Description: Erection of a 4 bed detached
house and detached double
garage

Location: Adjacent Cromwell House
Holbeach Bank
Spalding
Lincs

Amendment: Link added between house and garage and general alterations
Dwg. Nos. SD01-025/1C and MAY-01D

**RE: 4 BEDROOM DETACHED HOUSE ADJACENT CROMWELL HOUSE HOLBEACH
CLOUGH FOR FENBANK BUILDERS**

HURRICANE

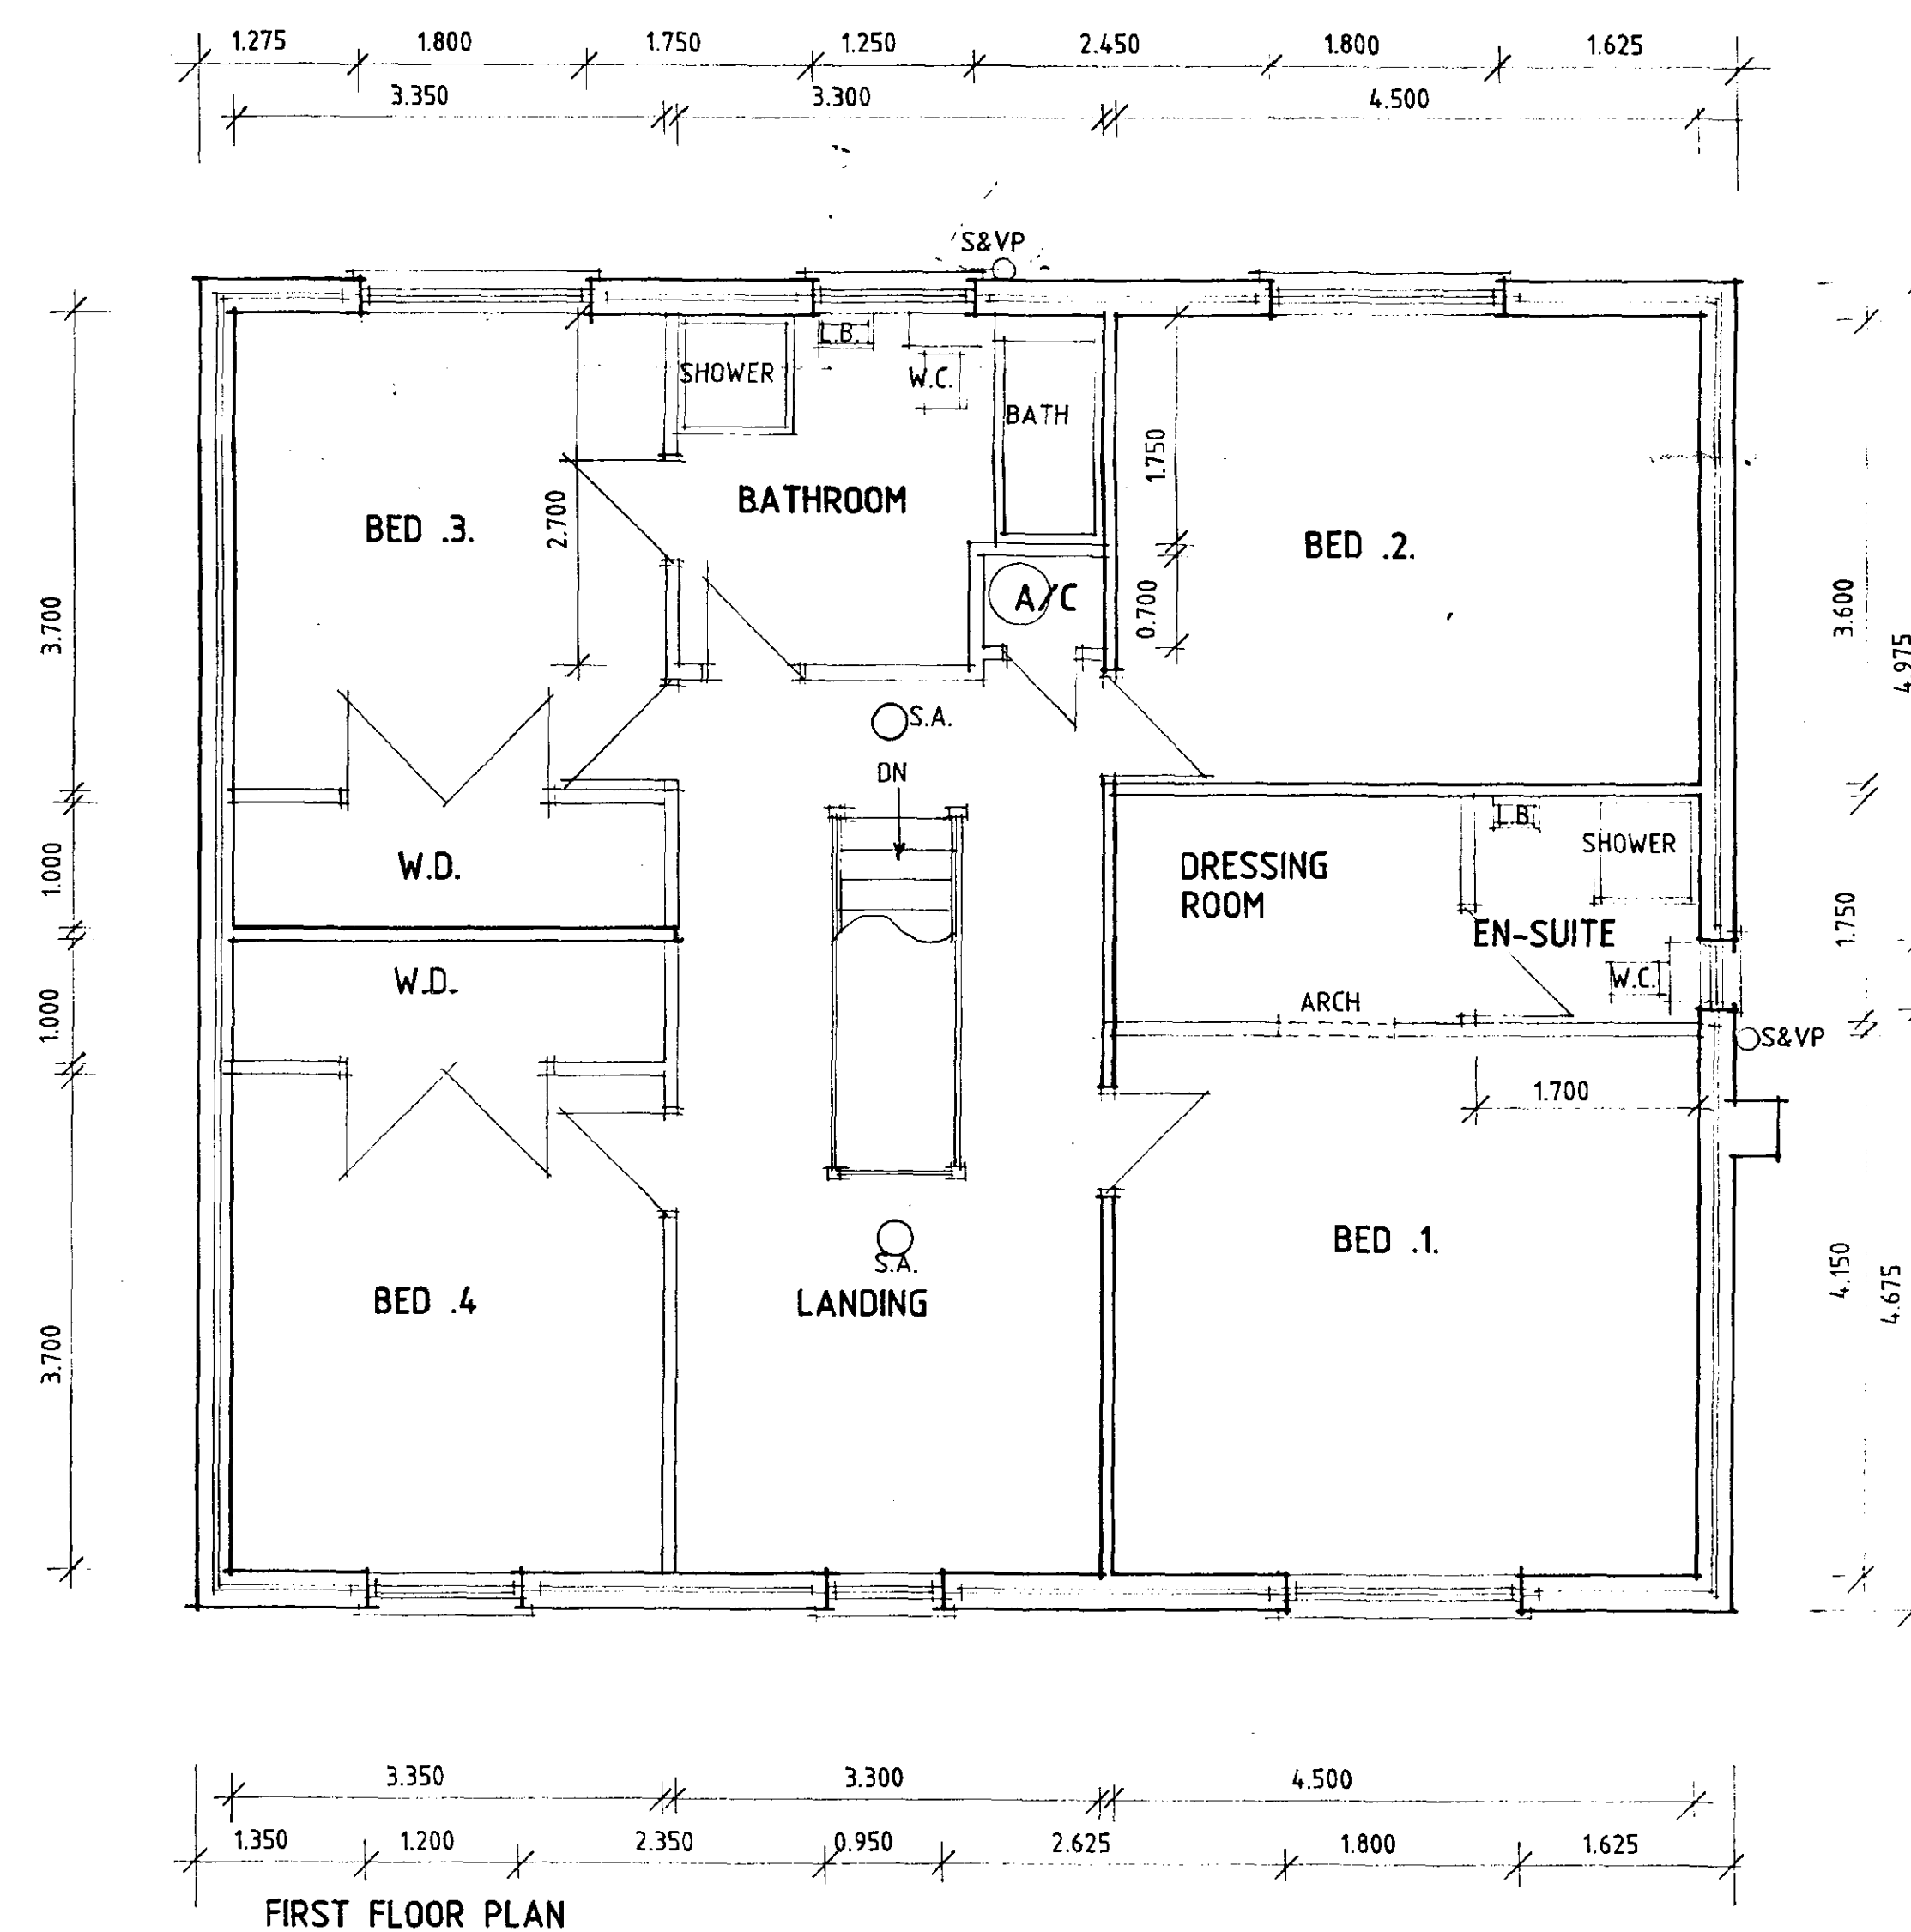
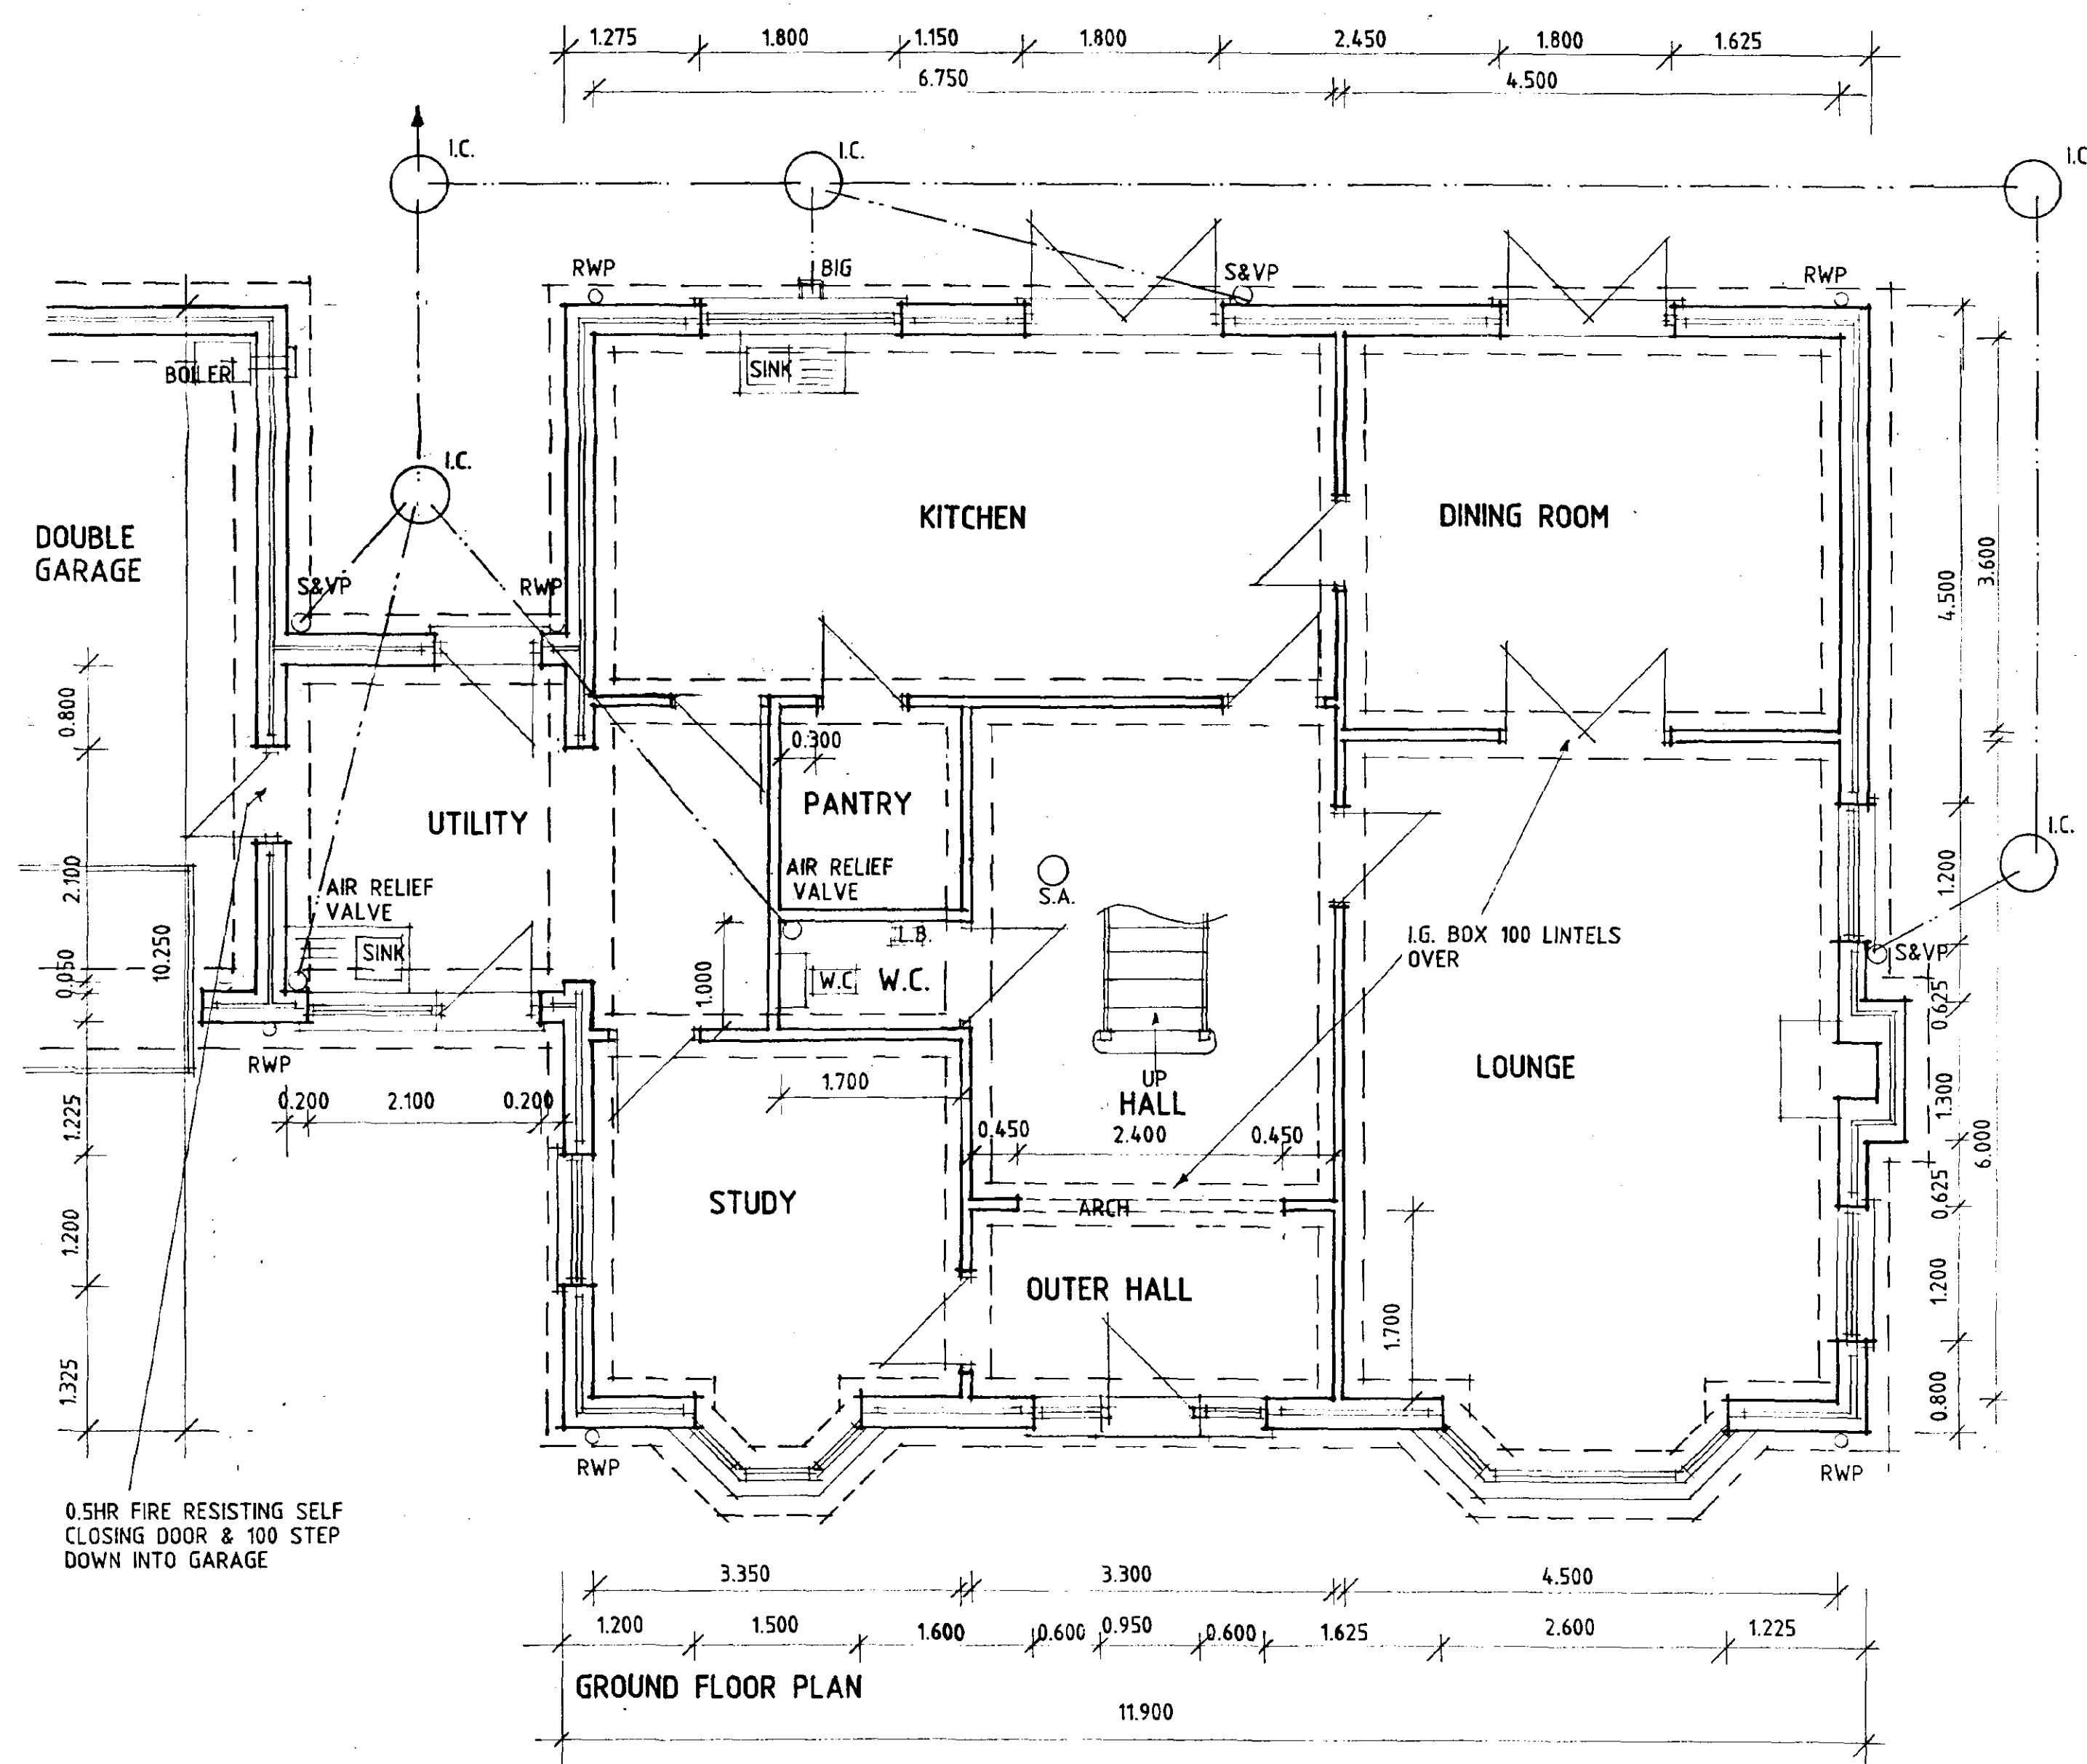
LINK ADDED BETWEEN HOUSE
& DOUBLE GARAGE & GENERAL
ALTERATIONS

There have been general alterations to the above proposal including a link between the house and double garage. I therefore enclose the following:
